## Engineers Comments Regarding Surface Water Drainage

| <b>Application Reference:</b>   | WA/50/25/DOC                                                                                                                                                                                                                                             | <b>Reviewer Reference:</b> | ADC/EXT4   |
| <b>Site Name:</b>               | Fleurie Nursery Lake Lane Barnham PO22 0AL                                                                                                                                                                                                               |                            |            |
| <b>Application Description:</b> | Approval of details reserved by condition imposed under reference WA/75/20/PL relating to condition number 3 - surface water drainage scheme, condition number 4 - surface water drainage system and condition number 7 - surface water drainage scheme. |                            |            |

Outfall B (South)

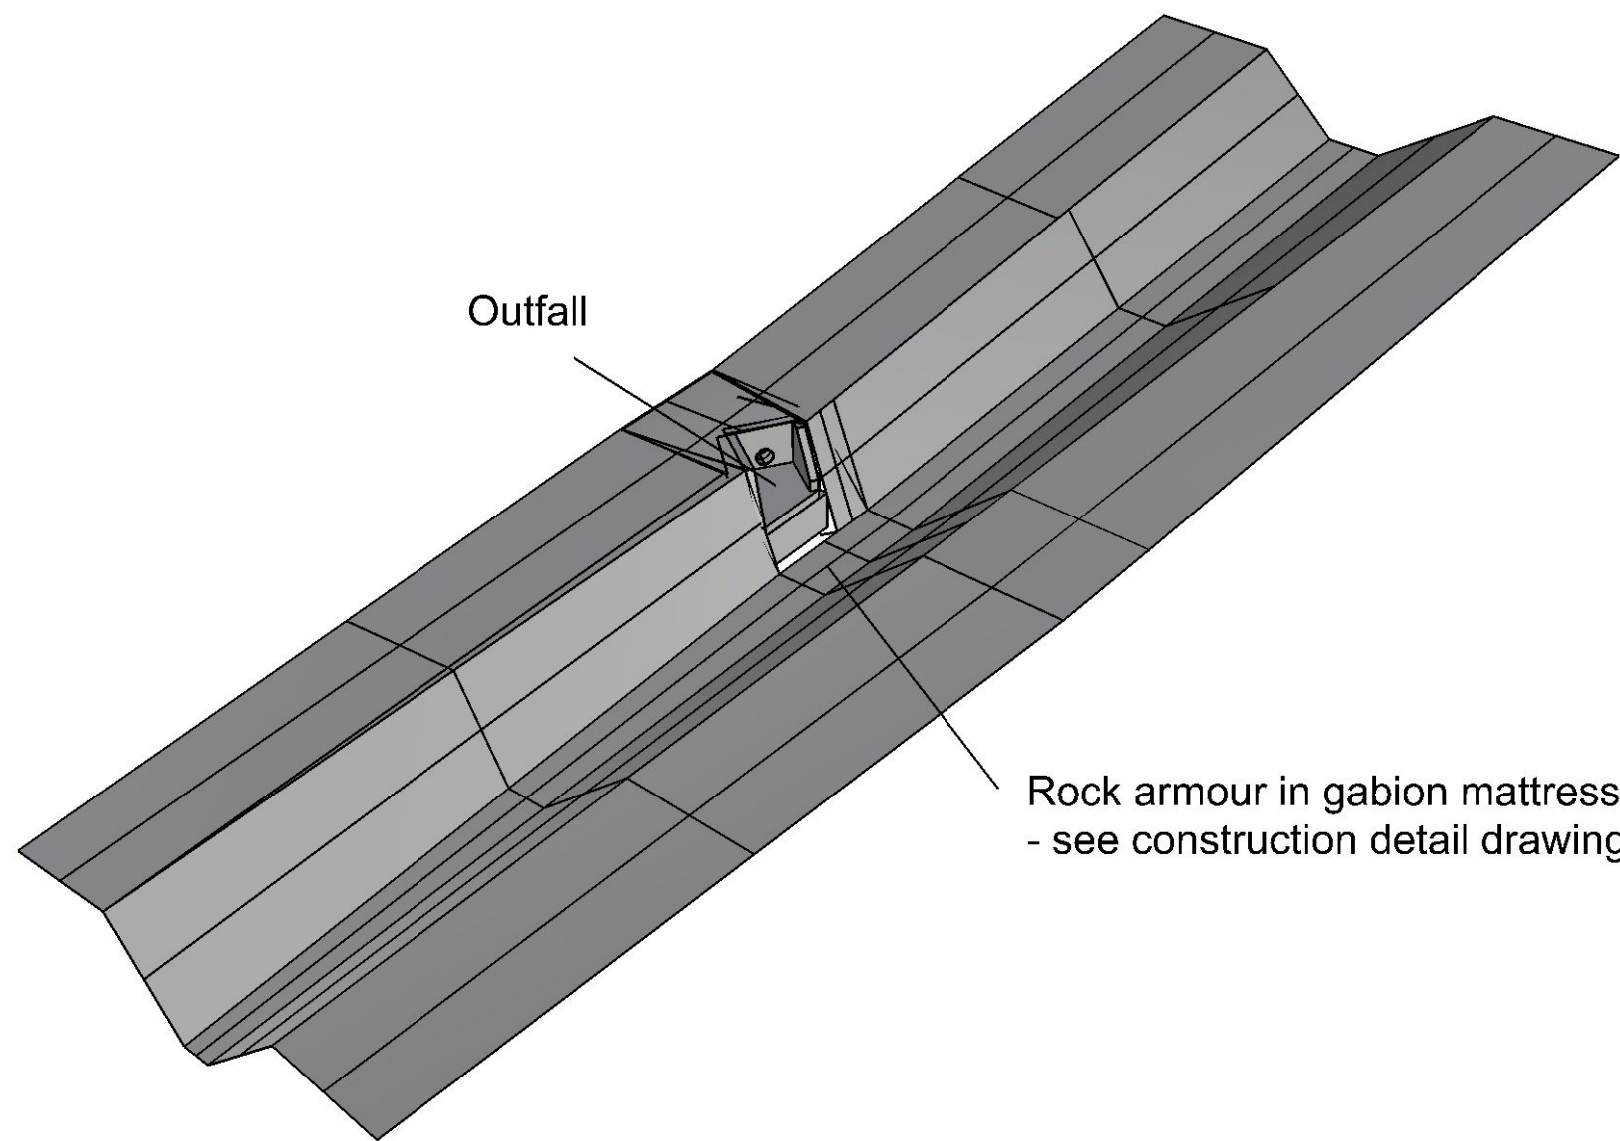
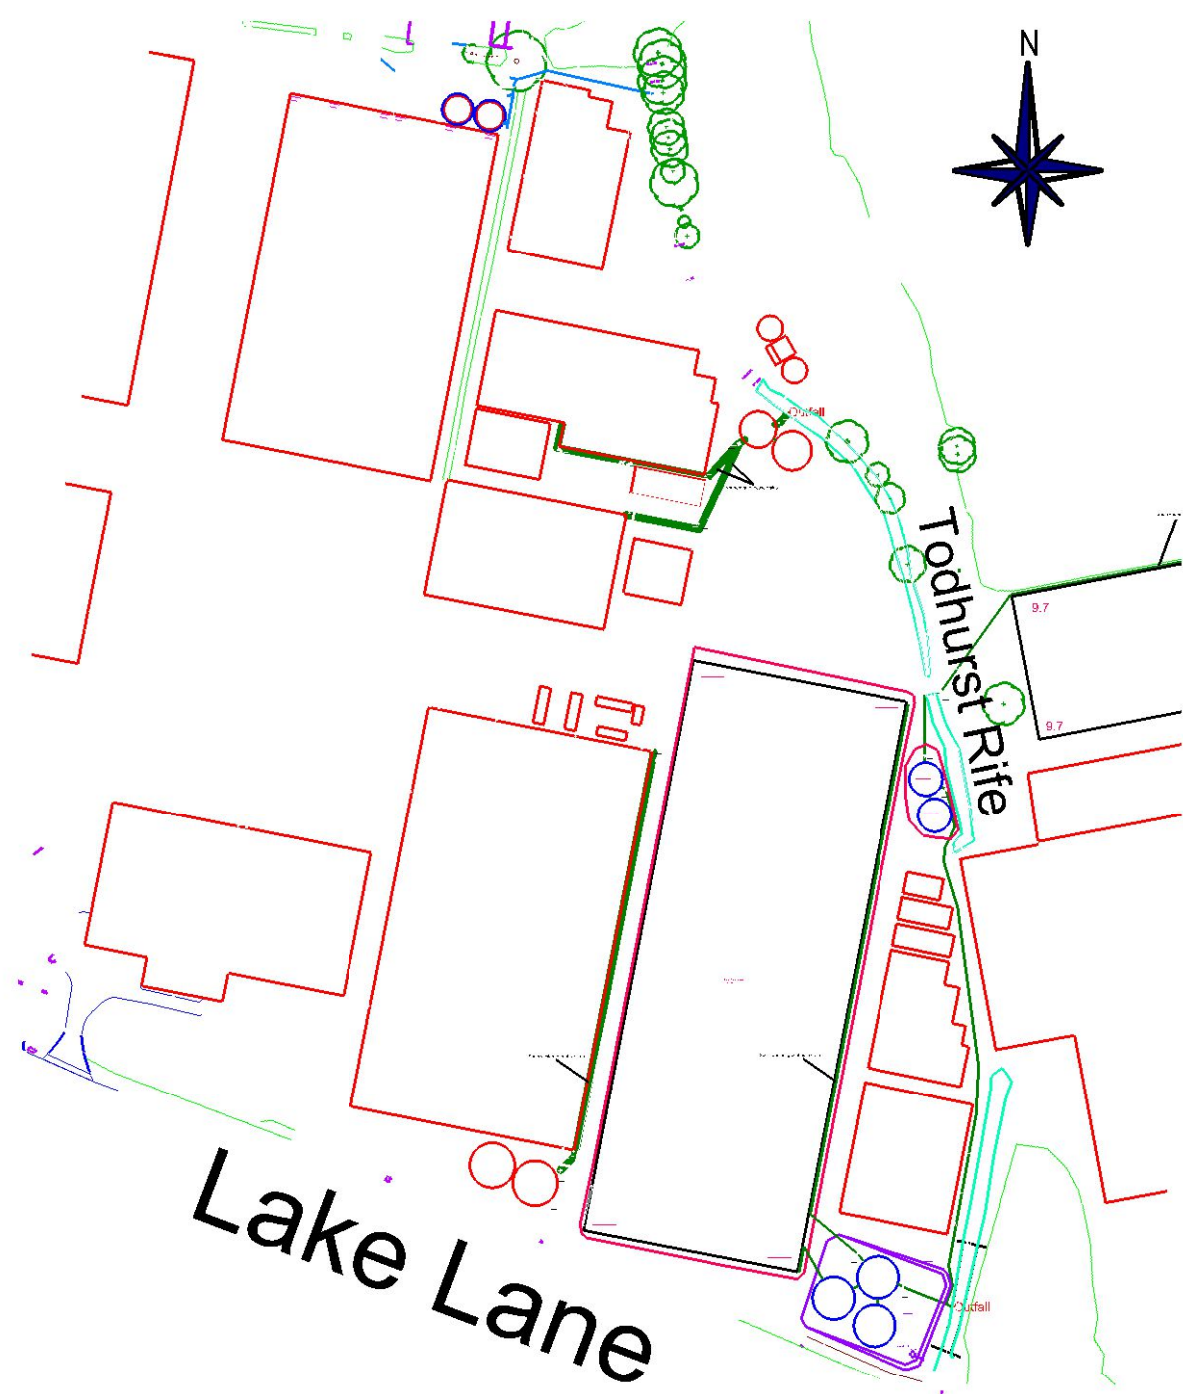
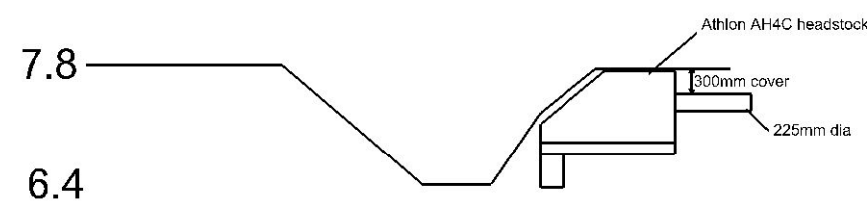
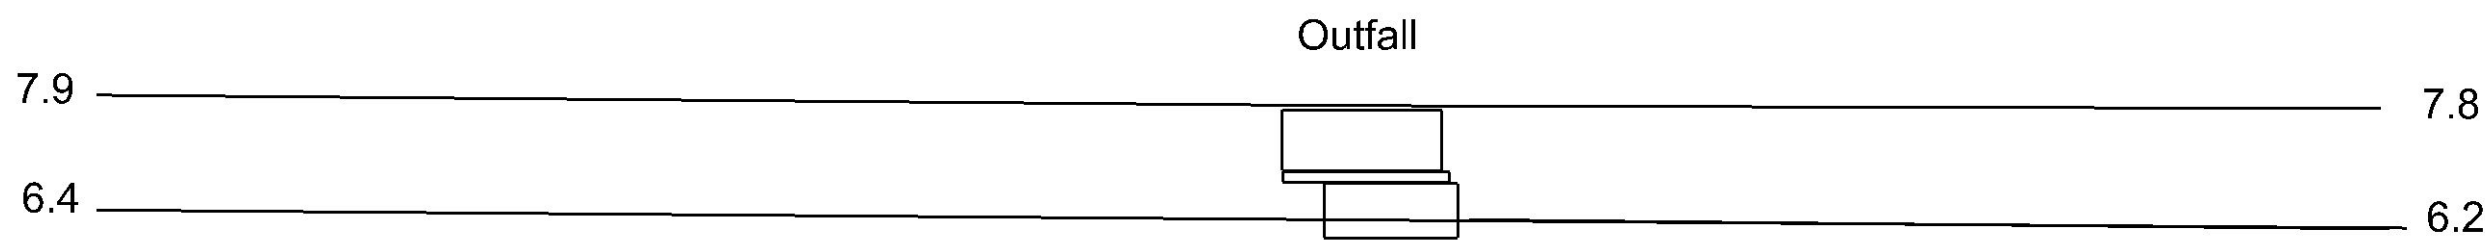
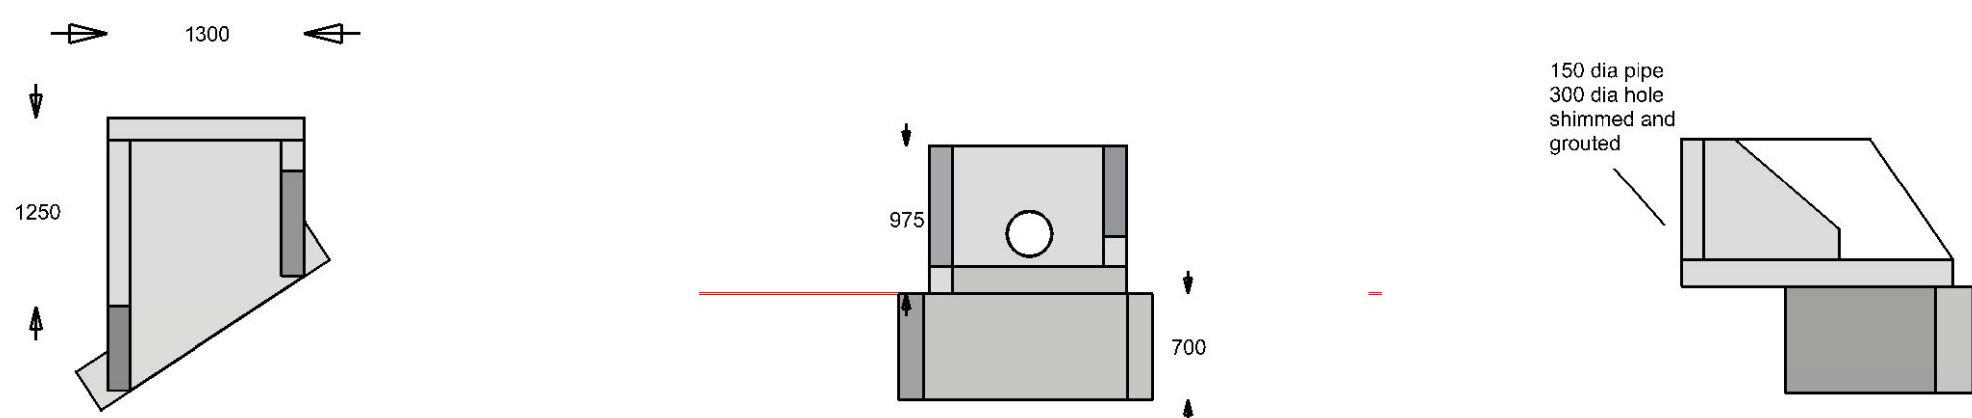
|                            | ADC Drainage Comments                                                                                                                                                                                                                                                                                                              | Designer Response |  |  |  |
|----------------------------|------------------------------------------------------------------------------------------------------------------------------------------------------------------------------------------------------------------------------------------------------------------------------------------------------------------------------------|-------------------|--|--|--|
| 6.                         | The headwall outfall details provided are insufficient and do not provide any construction details on specific type of headwall, bedding details, interface with the existing earthworks etc..                                                                                                                                     |                   |  |  |  |
